SSD 6471 SYDNEY MODERN, AGNSW EXPANSION PROJECT - RESPONSE TO SUBMISSIONS ADDENDUM REPORT, EXCL MARITIME ARCHAEOLOGY.

Thank you for the invitation received 10 August 2018 to respond to the Art Gallery of NSW's (AGNSW) Response to Submissions Addendum 1 Report dated 8 August 2018. The following documents were reviewed.

Attachment: Heritage Council comments on Addendum 1 modifications.

23 August 2018

PLAN SHOWING PROPOSED SUBDIVISION OF PART OF EASTERN
DISTRIBUTOR, BEING LOT 108 IN D.P. 1105308
IN SYDNEY L.G.A.

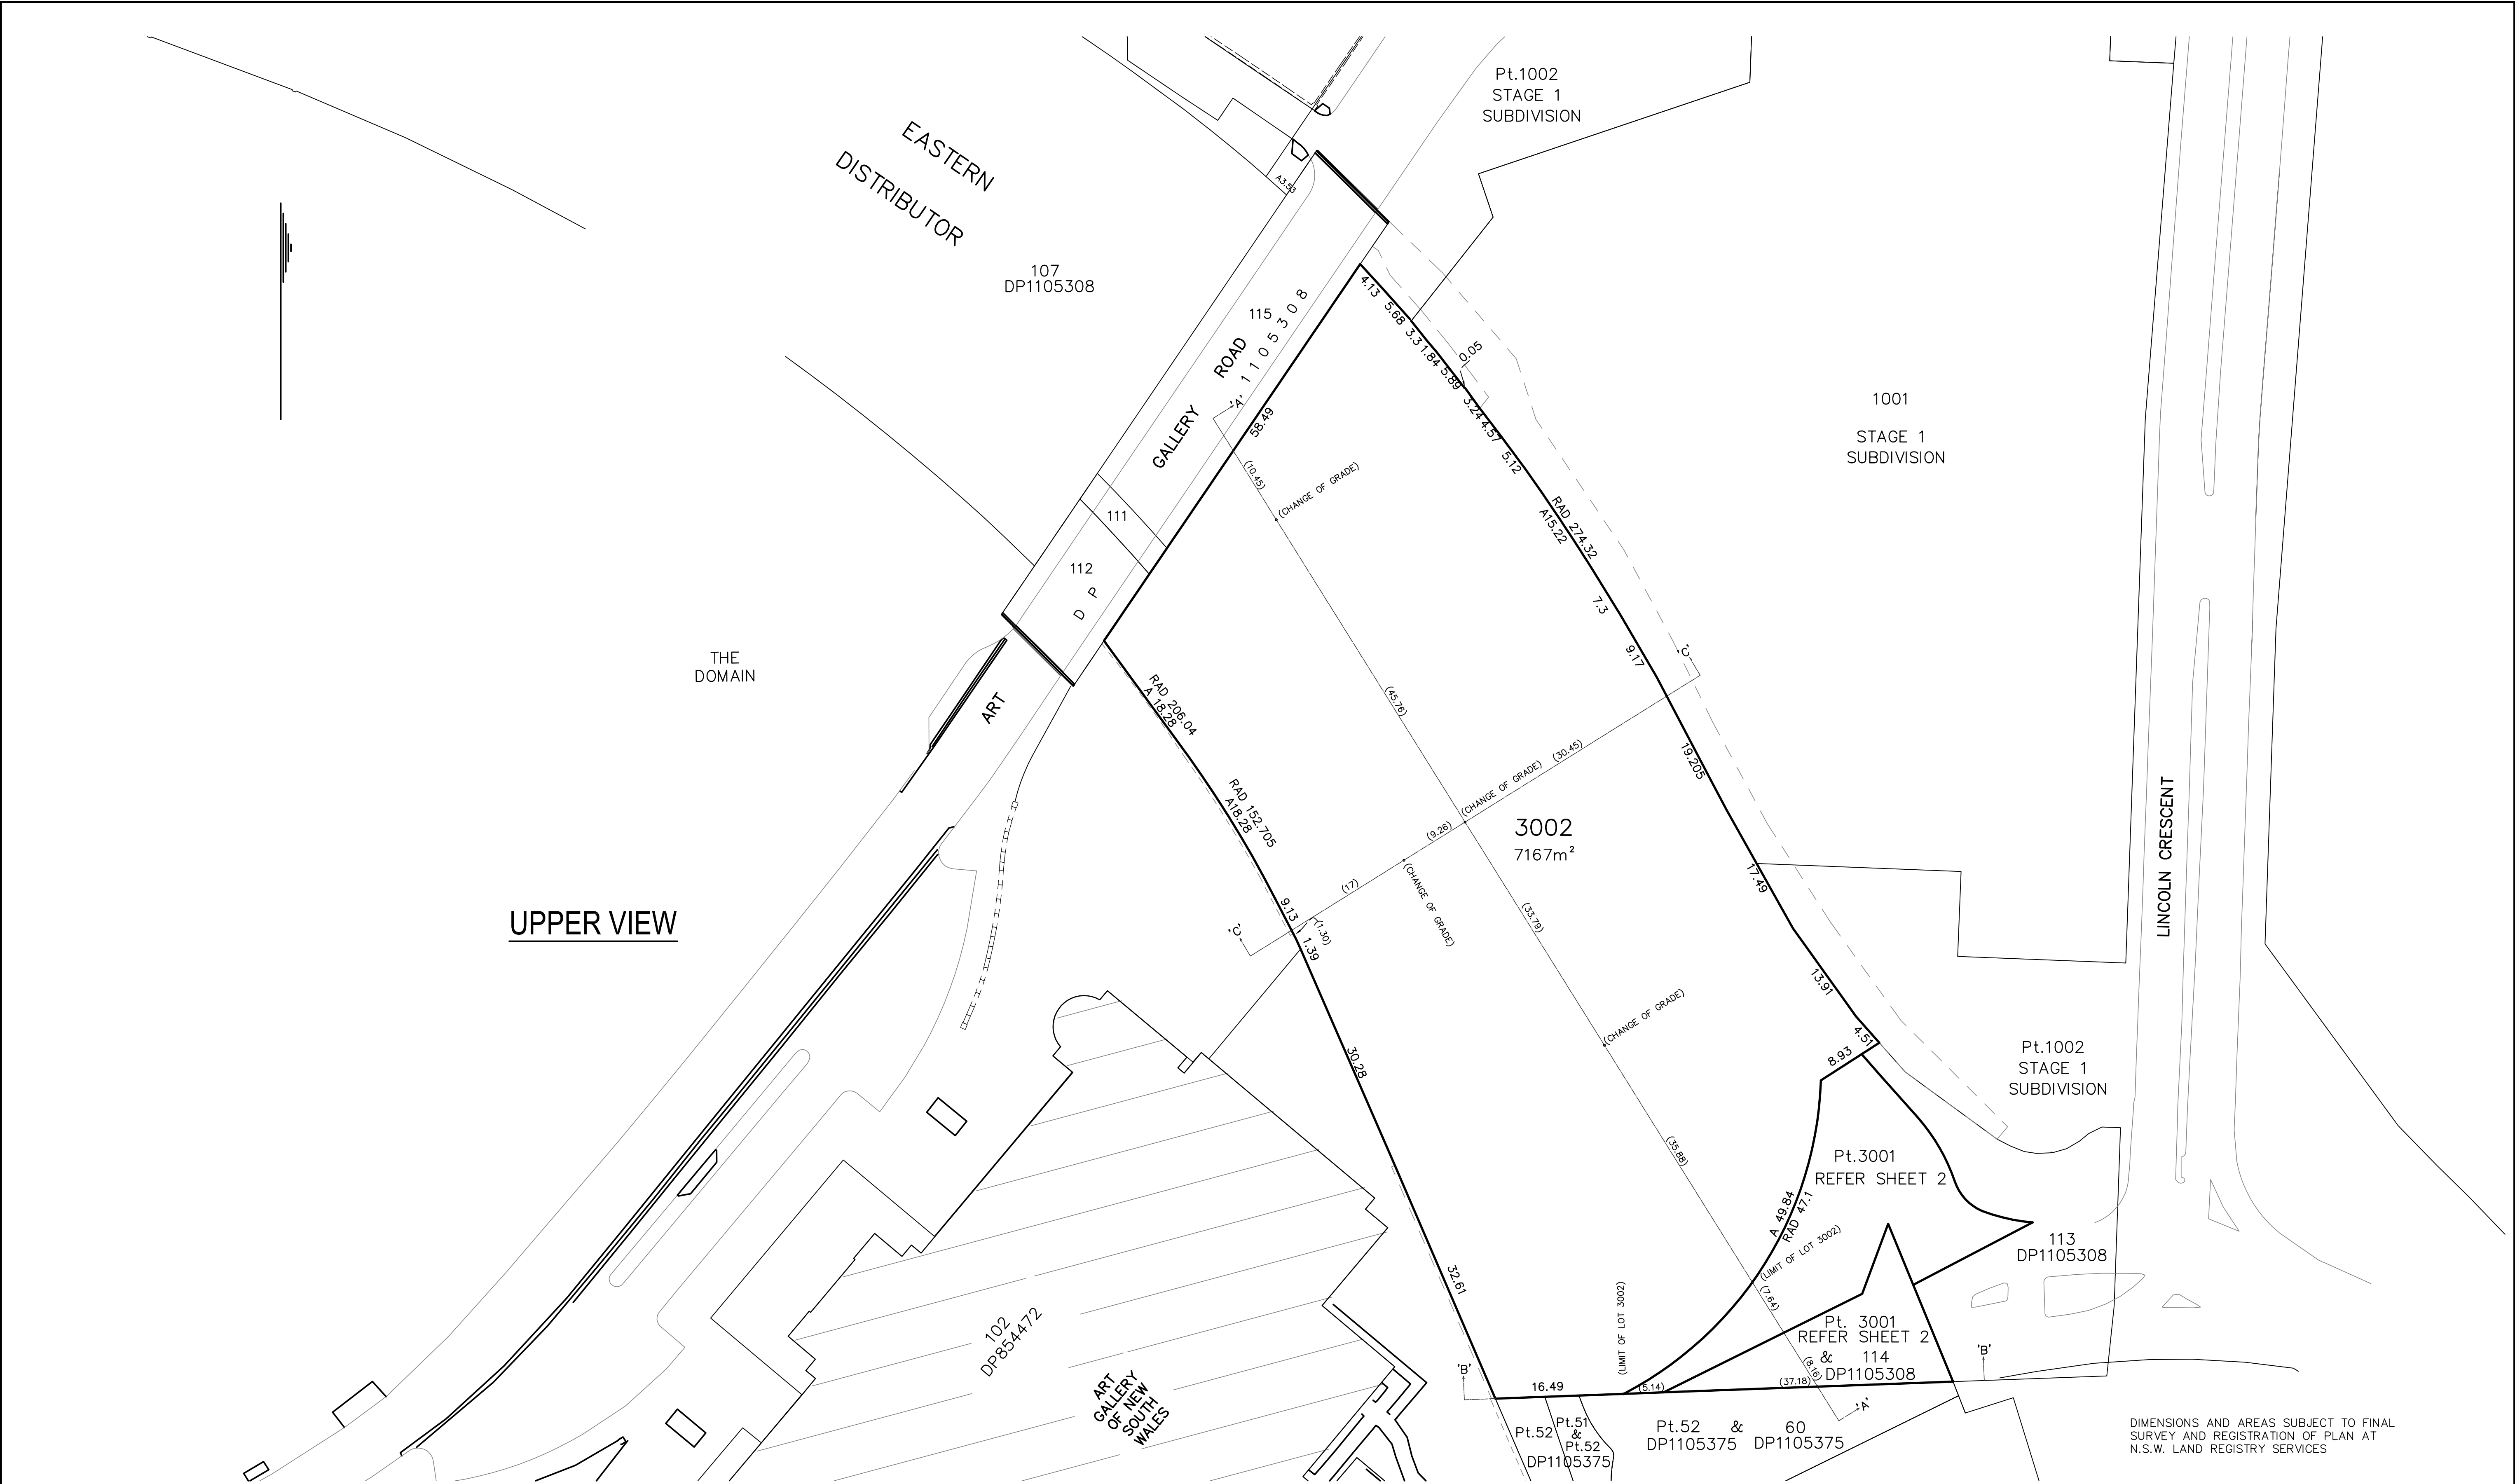
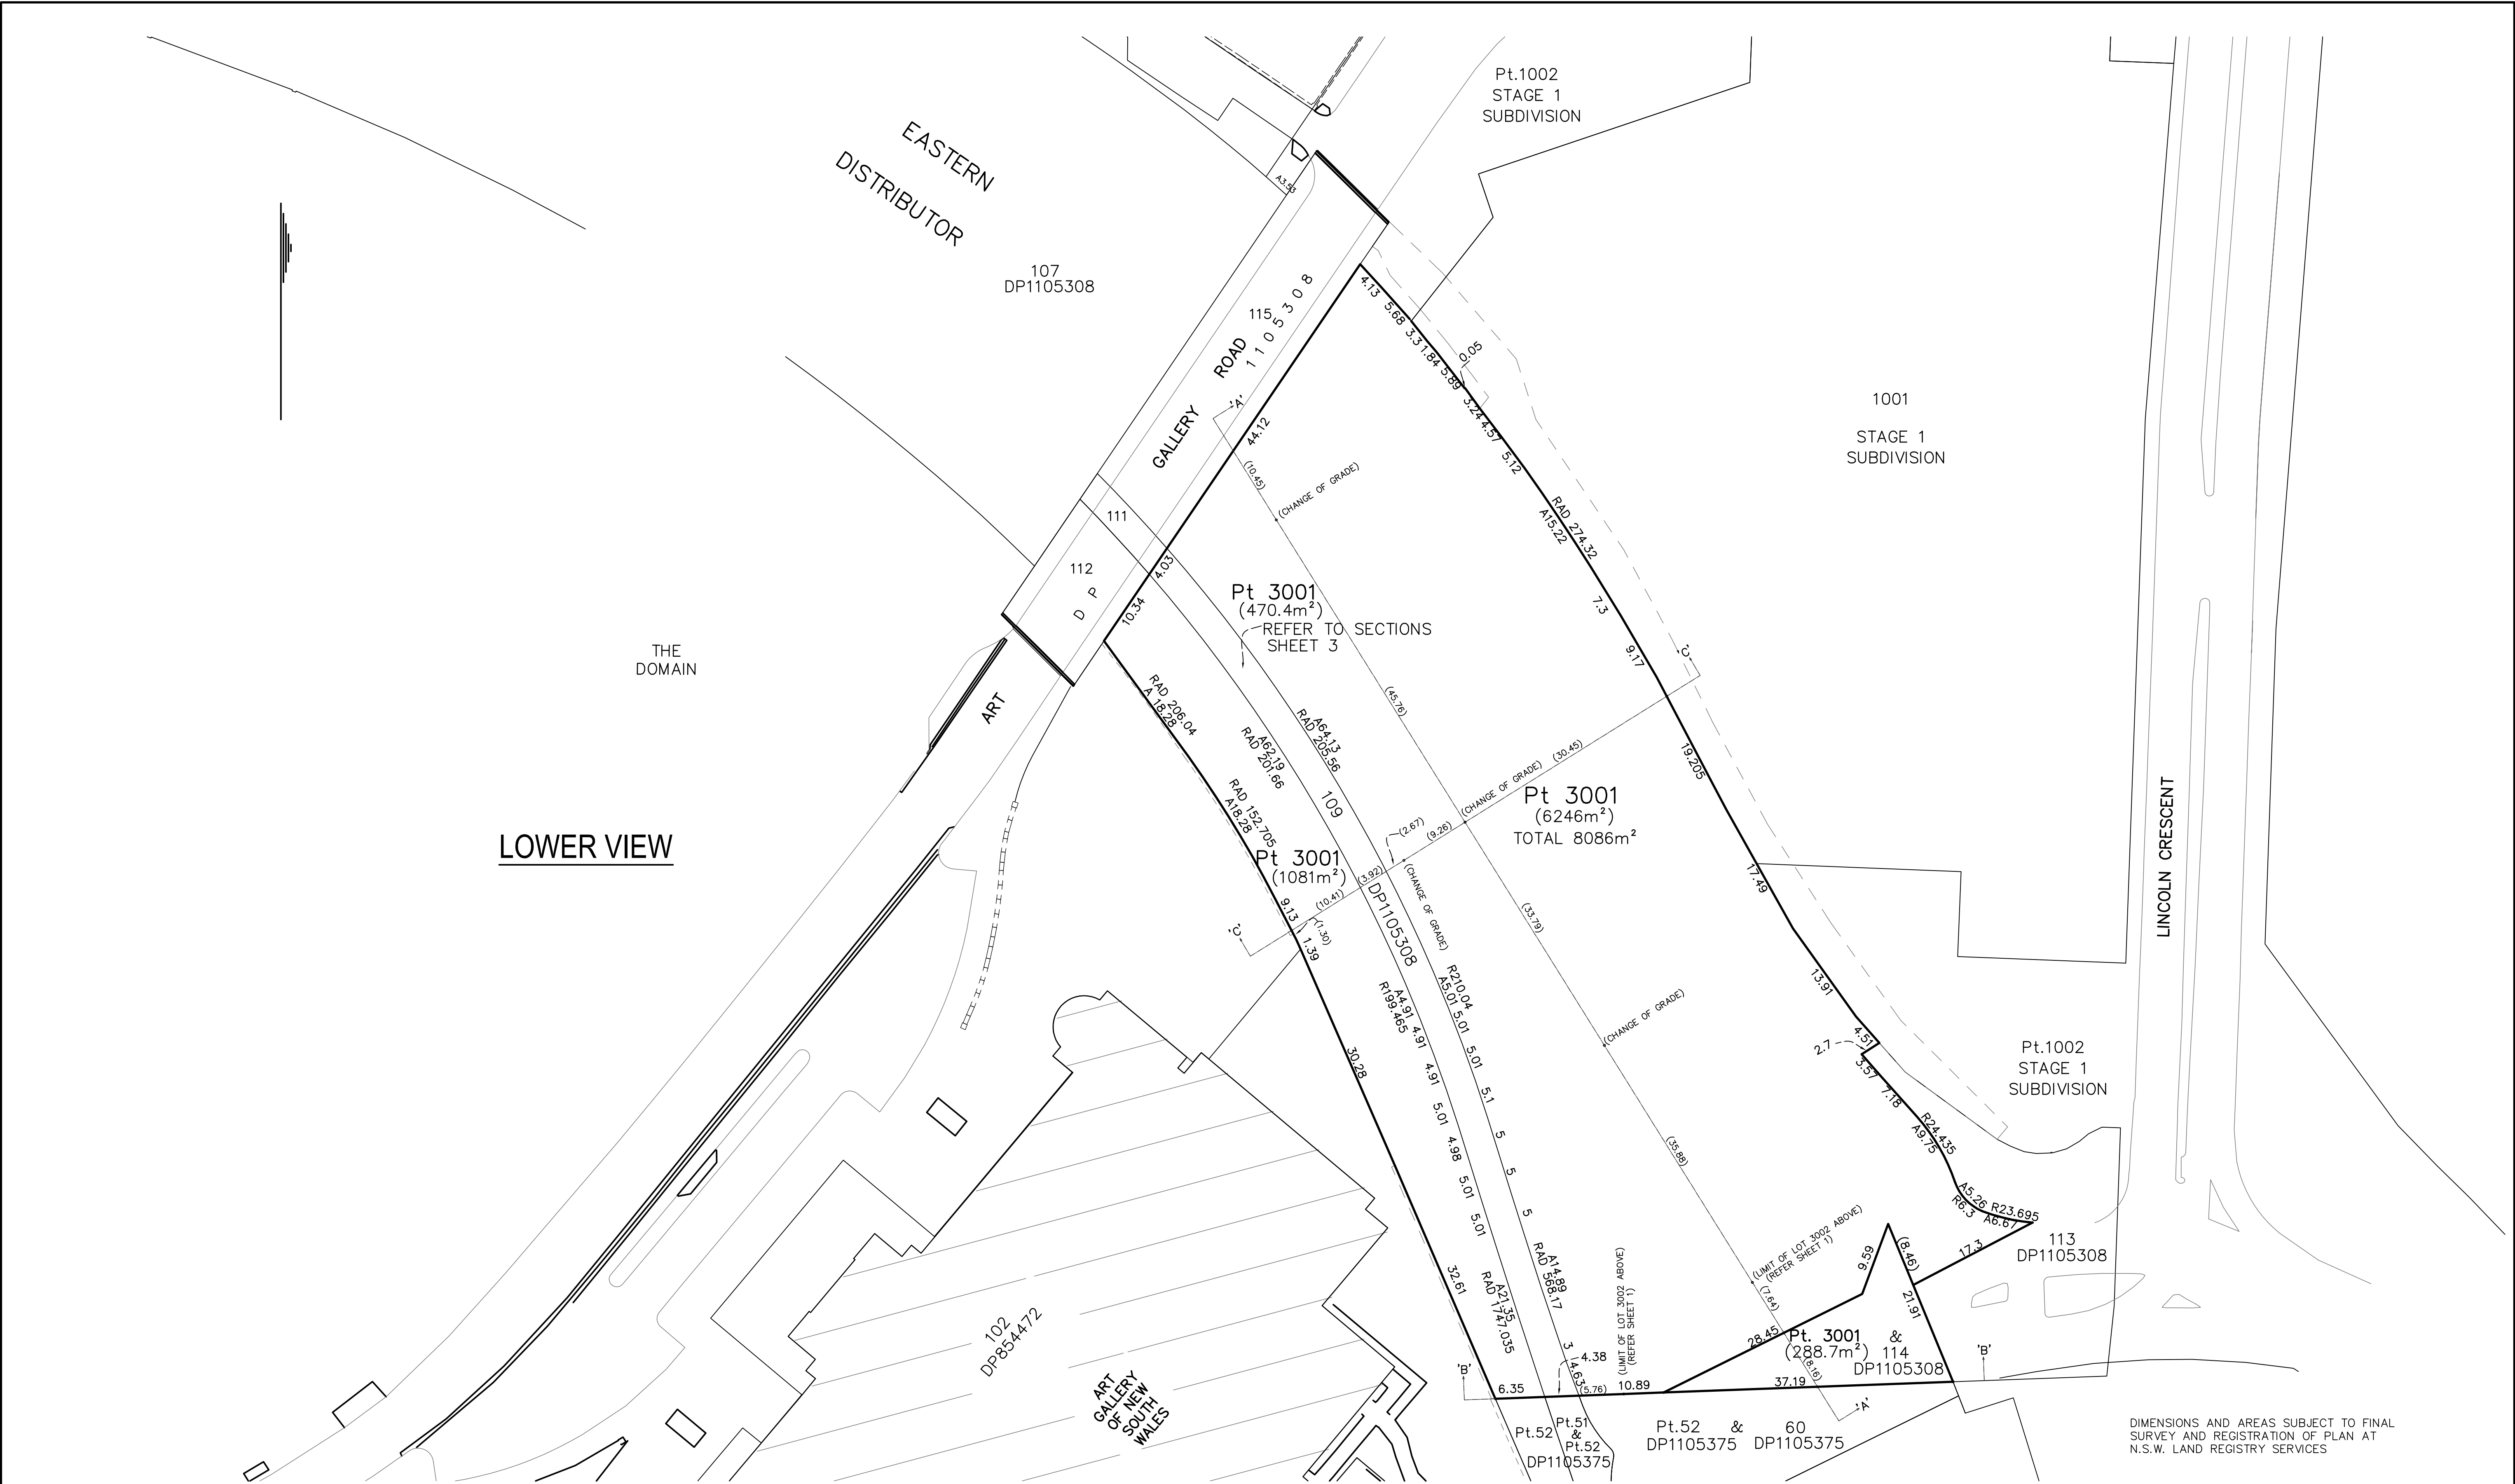
7	Subdivision	<p>It is noted that subdivision plans were not submitted and assessed with the Environmental Impact Statement. However, subdivision plans were submitted with this addendum.</p> <p>The subdivision affects the Sydney Modern AGNSW expansion site only. The subdivision formalises land ownership and use between the Royal Botanic Gardens and Domain and the land acquired for the Art Gallery expansion. The current subdivision of the Royal Botanic Gardens and Domain, in two main lots with subsidiary lots, does not have any historic value, but is the result of development in and around the park, particularly the advent of the Domain tunnel. With this, the proposed creation of new lots for the new Art Gallery extension and landscape will not adversely affect the Royal Botanic Gardens and Domain greater than the development itself.</p>
